Application Ref:	2025/0220			 Ribble Valley Borough Council <hr/> www.ribblevalley.gov.uk
Date Inspected:	05/06/2025	Site Notice:	05/06/2025	
Officer:	EP			
DELEGATED ITEM FILE REPORT:				REFUSAL

Development Description:	Proposed single-storey extension to rear.
Site Address/Location:	4 West View Main Street Grindleton BB7 4RB.

Proposed Side Elevation  
(South East)

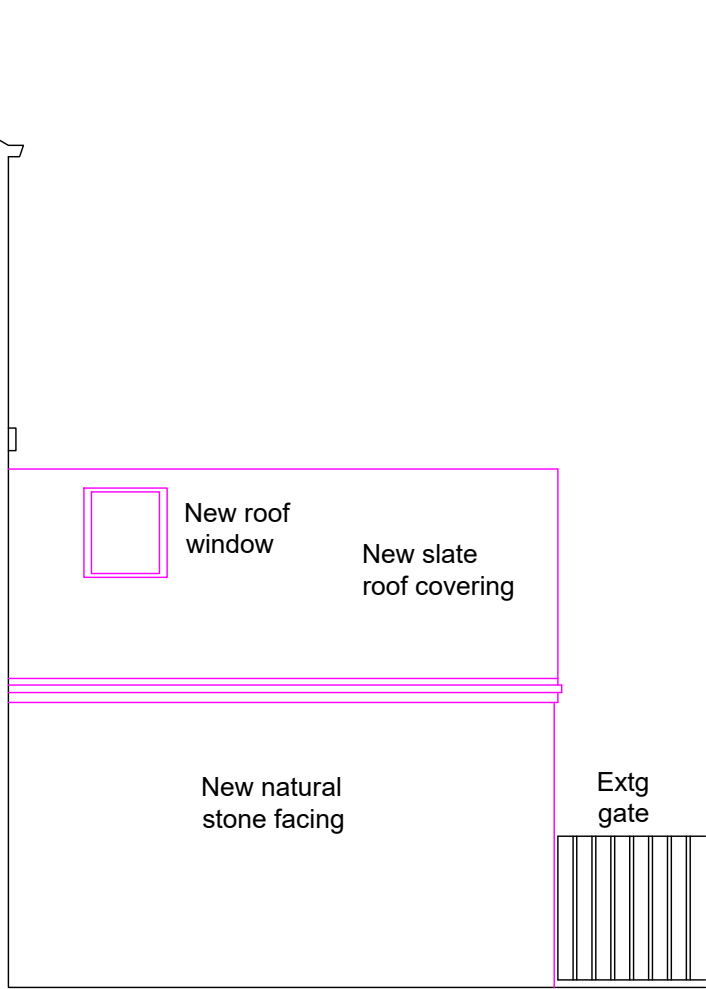
The proposed single storey extension is to project 3.61m rearwards and will extend the entire width of the existing dwelling. The adjoining dwelling to the south comprises an existing rear extension at the southern side of the property and also benefits from a ground floor habitable window at the northern side of the dwelling on the rear elevation. The proposed extension if implemented would lead to a tunnelling effect and sense of enclosure upon the occupying residents by virtue of its design and close proximity to the adjacent neighbouring window which provides light to a habitable room.

The proposed extension is to measure 2m to the eaves to the southern side but will have a maximum roof height of approximately 3.4m. Given there is no set in distance from the adjoining boundary, it would inflict an unacceptable overbearing impact and sense of tunnelling upon the neighbouring property. Furthermore, analysis shows that the extension would also be in contravention of the 45-degree rule in relation to the window previously discussed.

| 01: | The proposal is considered to be in conflict with policy DMG1 of the Ribble Valley Core Strategy in as much that the proposed extension, by virtue of its scale, proximity and orientation, would result in an unacceptable overbearing impact upon the residential amenities of the occupiers residing at the property immediately to the south also leading to an unacceptable loss of natural light. |
